Proposed New K-12 Educational Establishment

BLESSED CARLO CATHOLIC COLLEGE

Corner of Lignum Road and Kiely Road, Moama

The table below summarises comments received from the State Design Review Panel (SDRP) and resultant response incorporated into the final design for the proposed new Catholic school.

3 SHADOW Winter 1500
Scale 1 : 1500

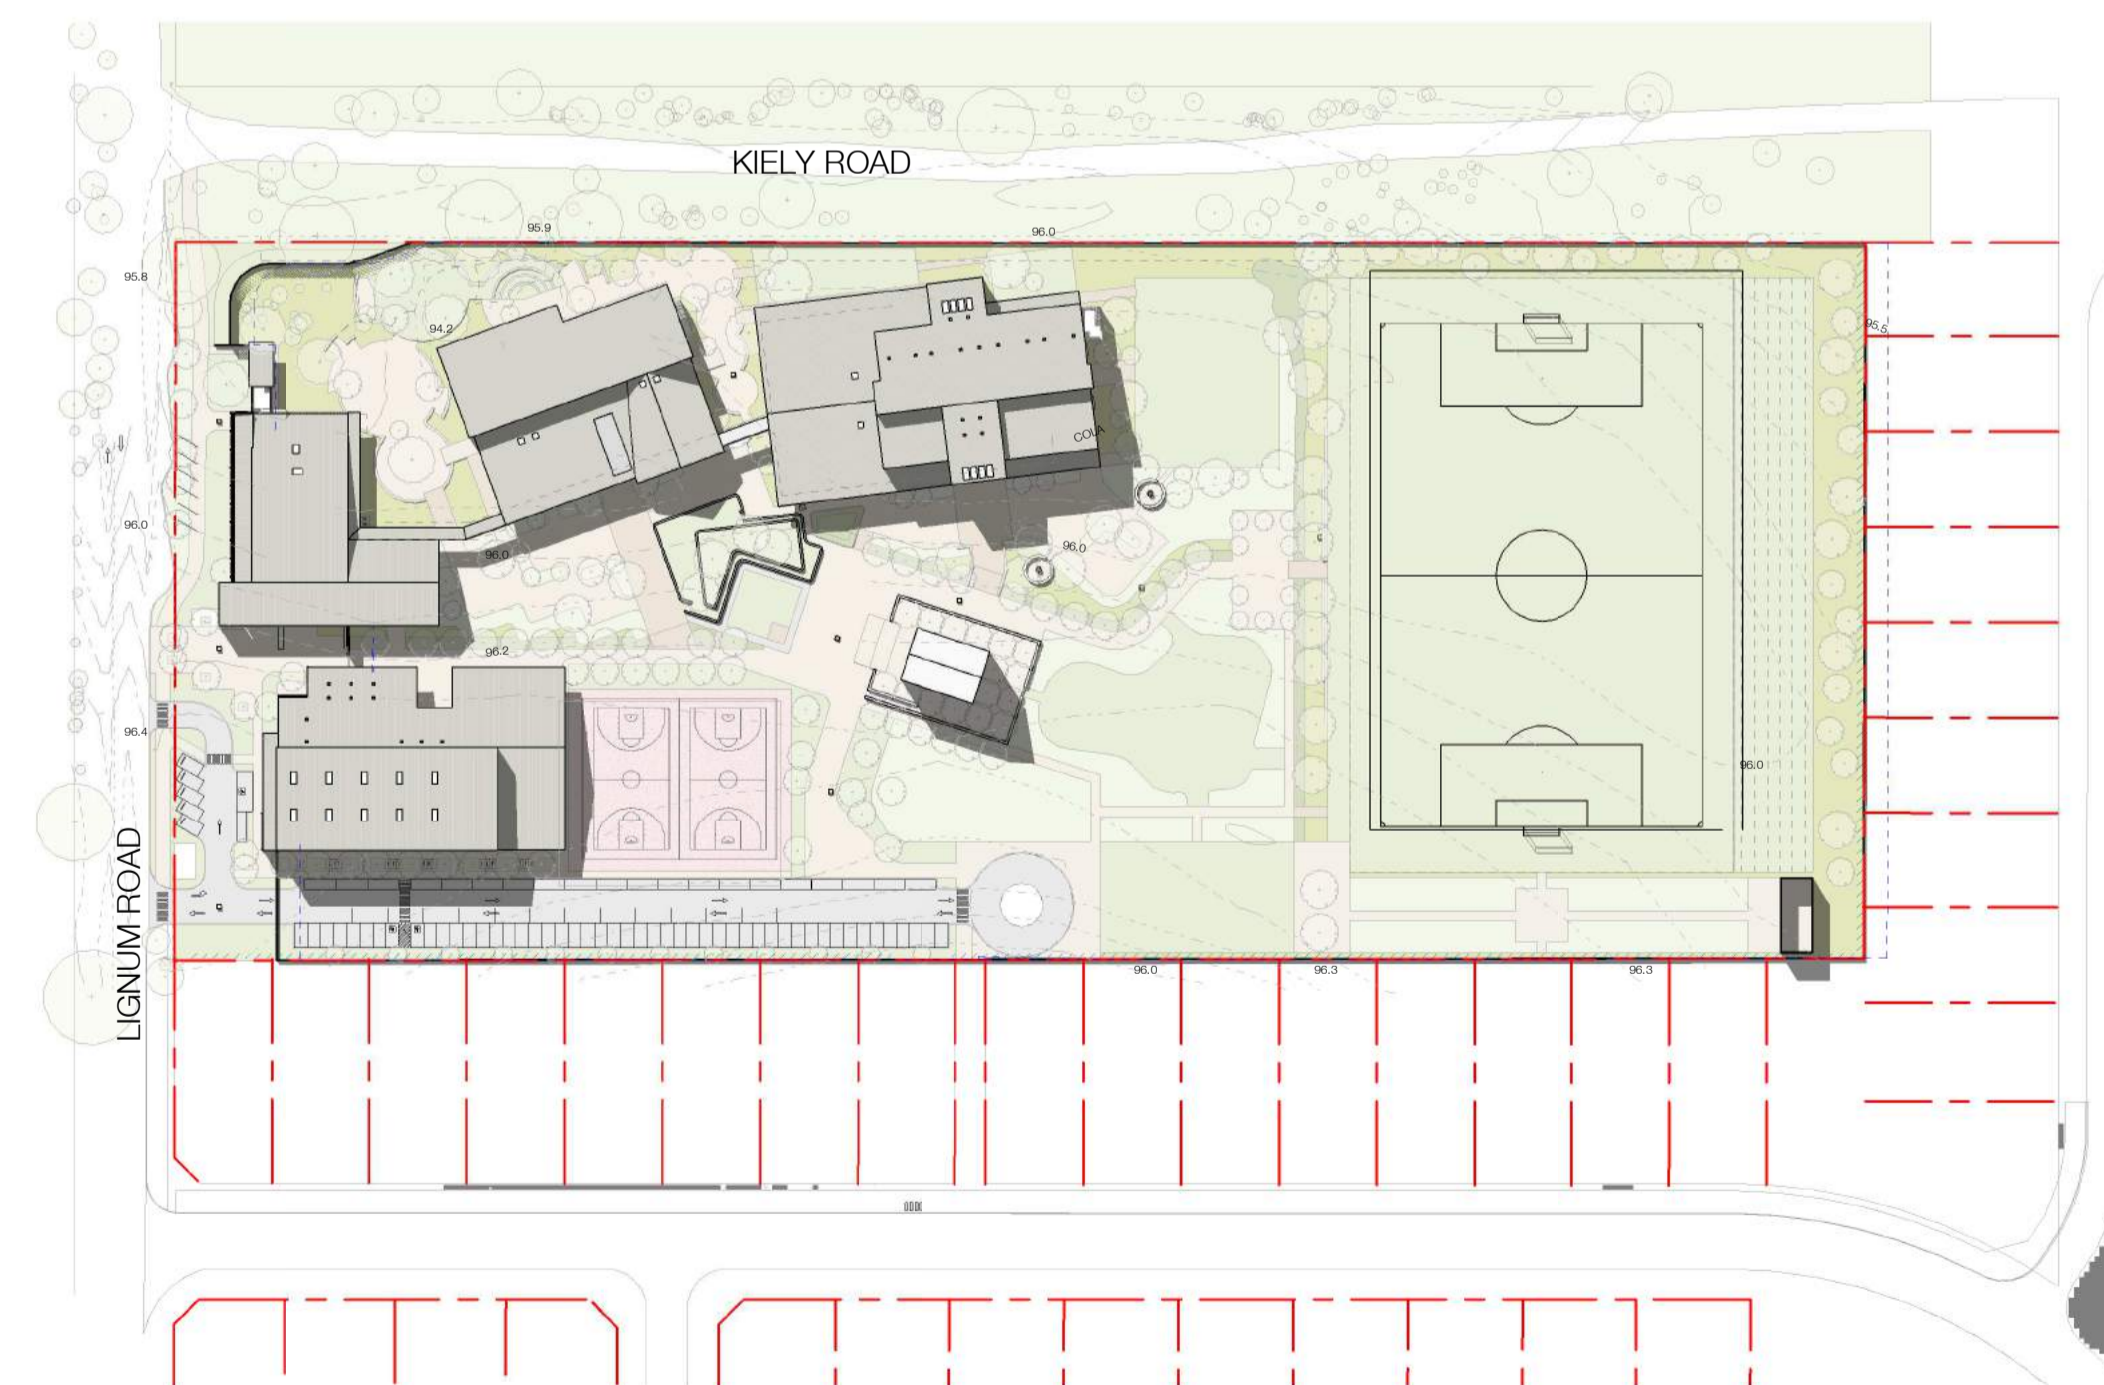
Northern edge of site appears to encroach on Council land, provide evidence this has been discussed with Council.	Satisfied, discussions with Murray River Council included in EIS.
Architecture	
Provide evidence of good sunlight access in interior spaces to support learning, comfort, and environmental demands.	Satisfied, provided in Architectural Plan Set.
Detailing and scale of colonnade requires further development.	Satisfied, provided in Architectural Plan Set.
Sustainability and Climate Change	
Develop a clearer sustainability strategy for design and how it is integrated into environmental and energy systems.	Satisfied, provided in Architectural Plan Set and Architectural Design Statement.
Envision project as opportunity to embody principles set out in Pope Francis' encyclical <i>Laudato Si</i> , demonstrating the school's commitment to caring for the environment through pedagogy and built assets.	Satisfied, considered during design development. See final Architectural Report.

Typical Fence 2 Section
Scale 1 : 20

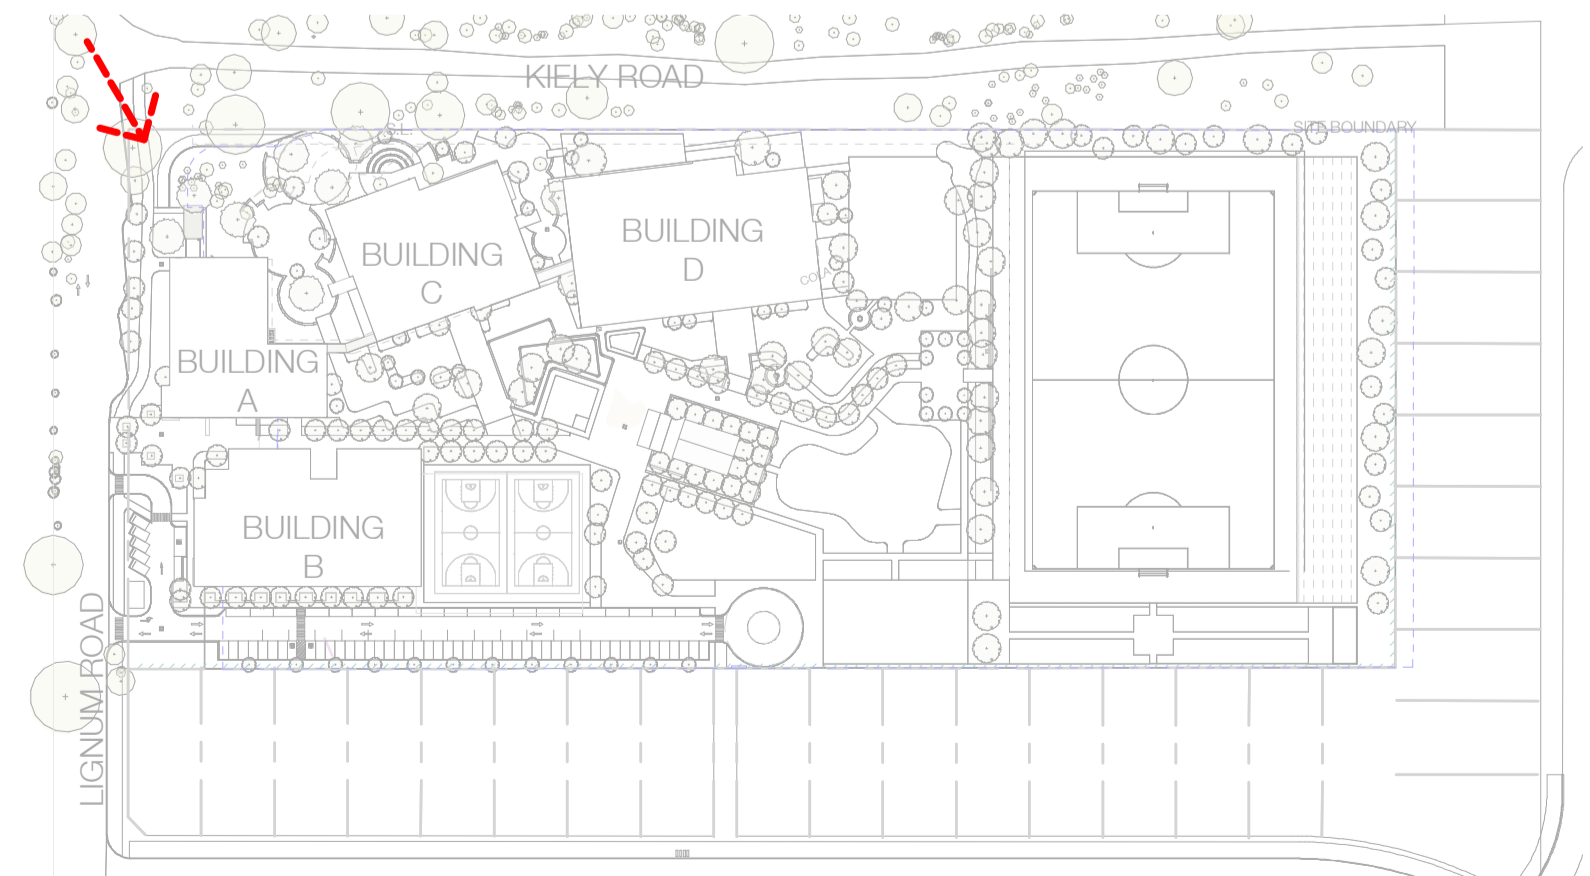
Specify fencing appropriate to rural or regional setting and avoid overly suburban or urban solutions that will impact on character of area.	Satisfied, implemented in Architectural Plan Set.
